ENG-PUDSP21001-R3-PDR_redlines.pdf Markup Summary

DRAINAGE MAPS

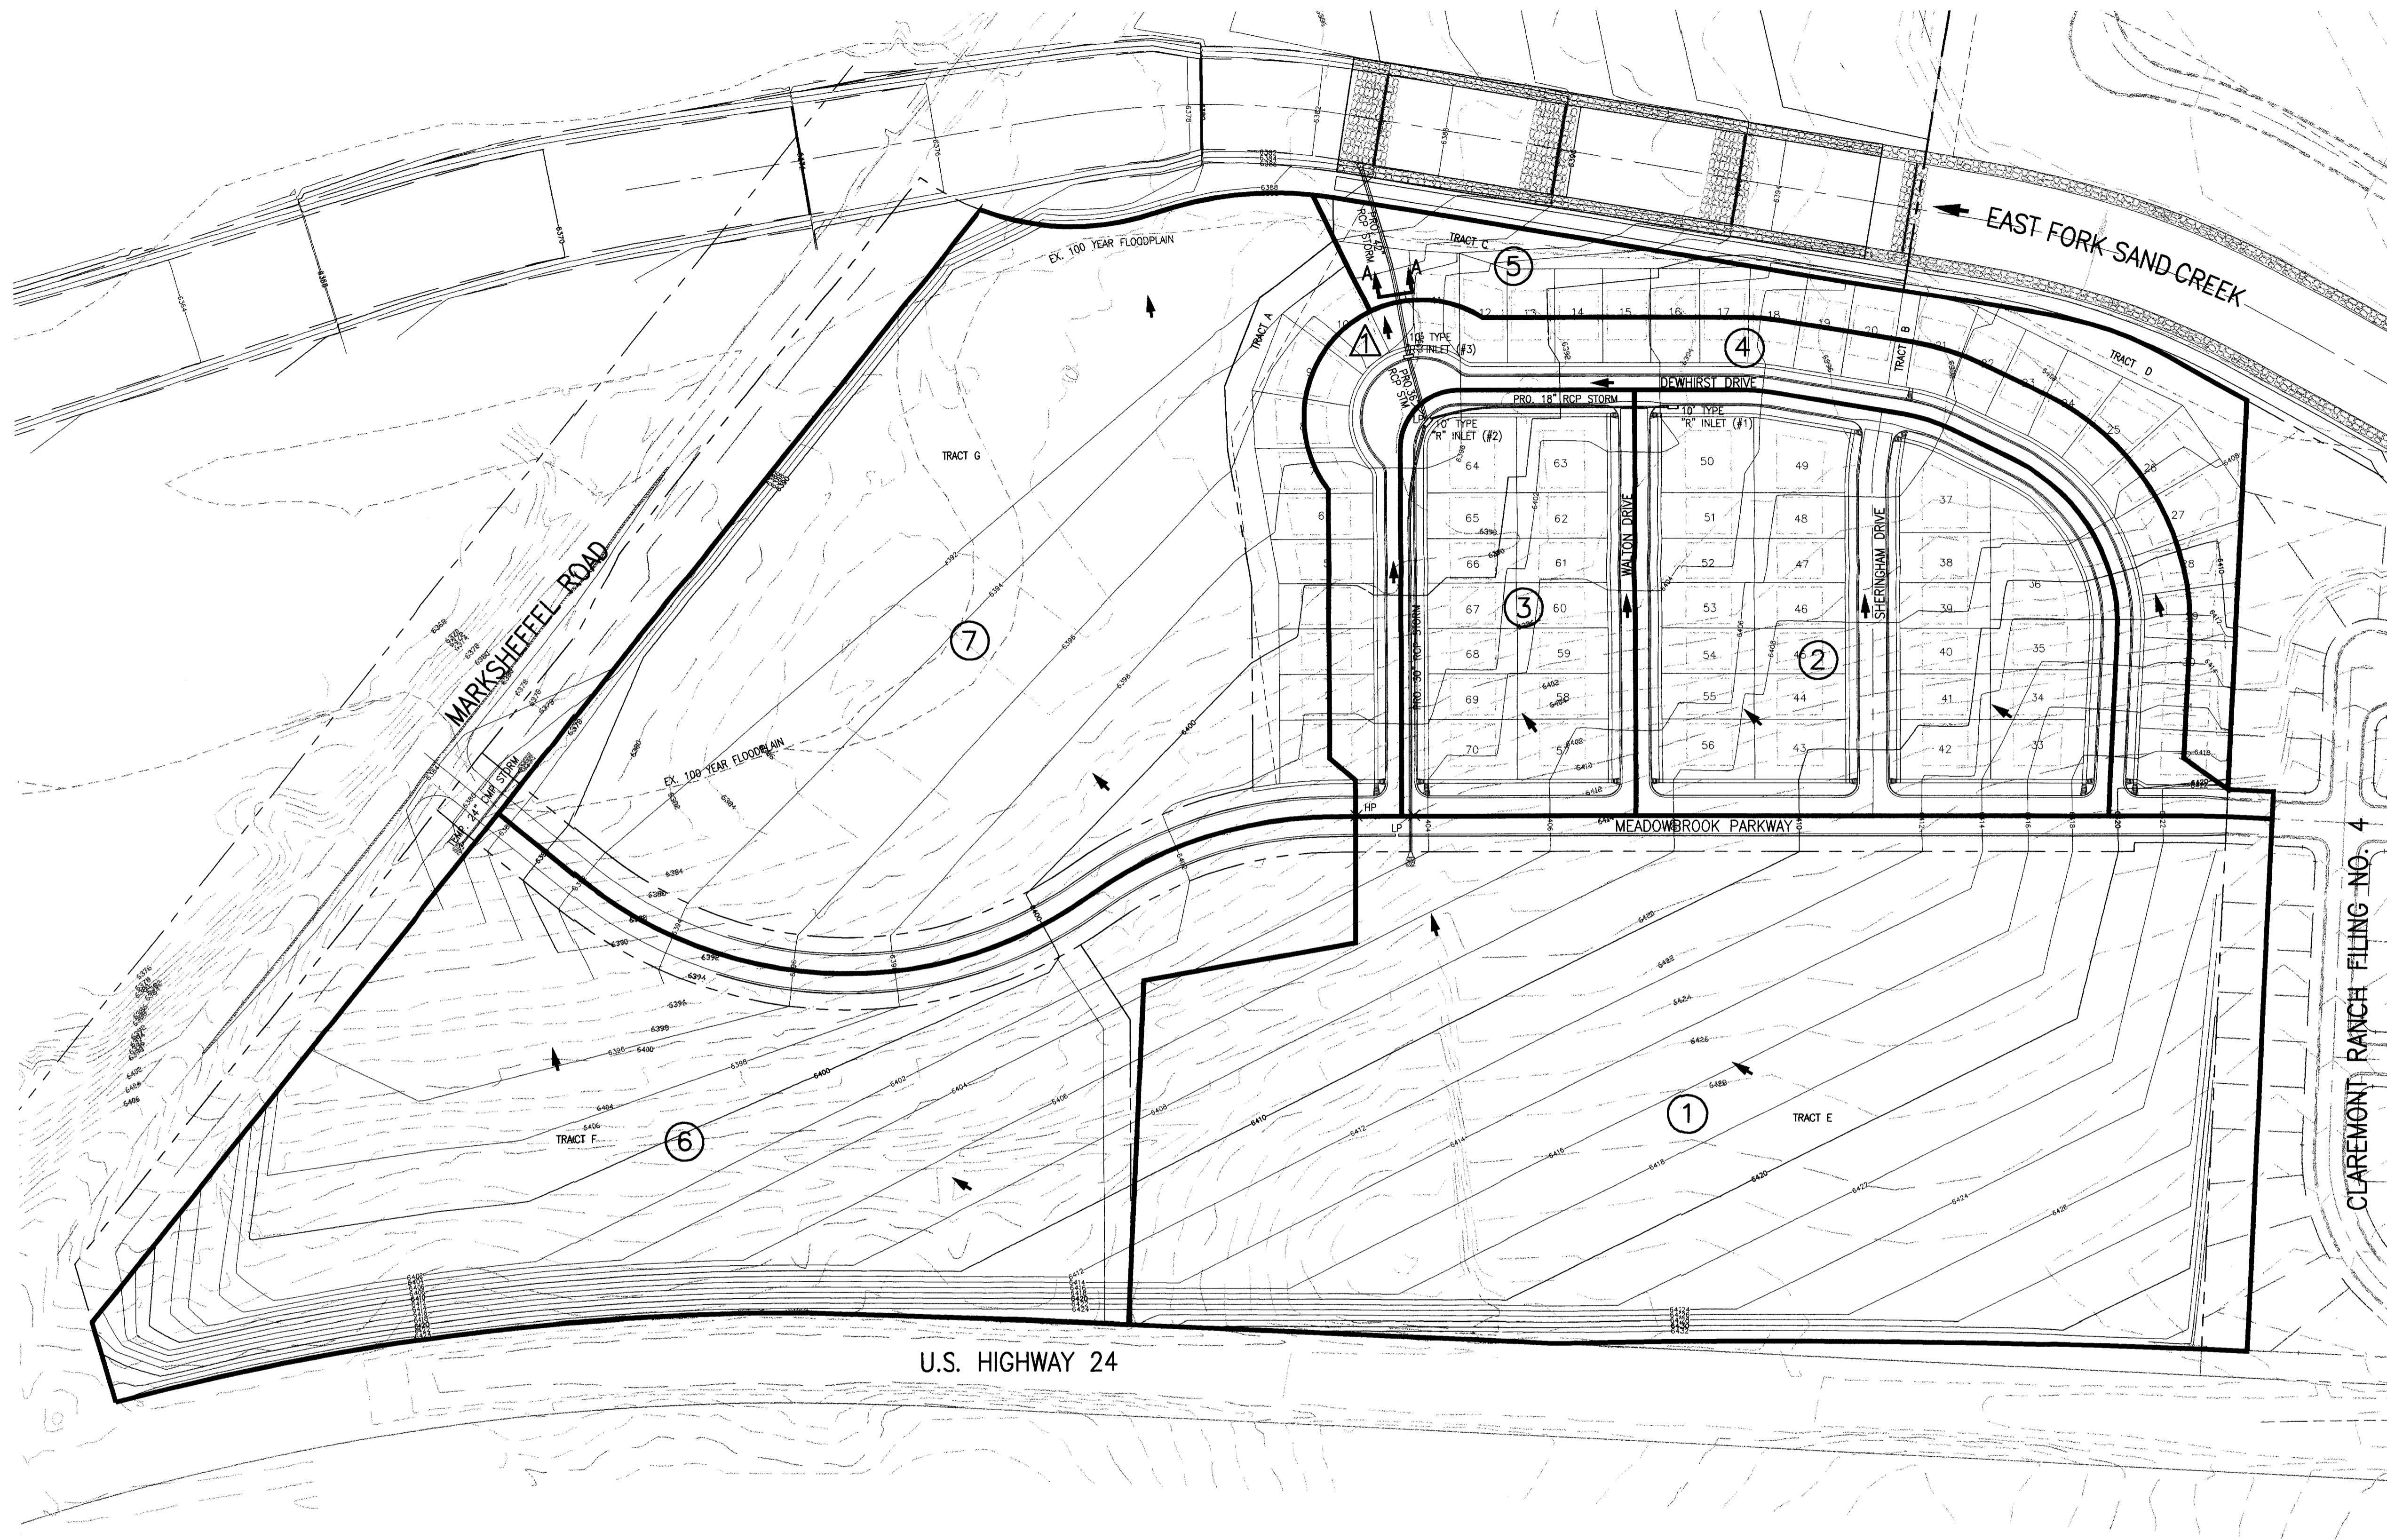
Turn off double Lot labels

Label what these areas are.

Unresolved:
Sidewalk chase?

Remove double text

Review 3:
Label and indicate in report that chase will be needed to convey swale flow into street. Design will be provided with Final Drainage Report.
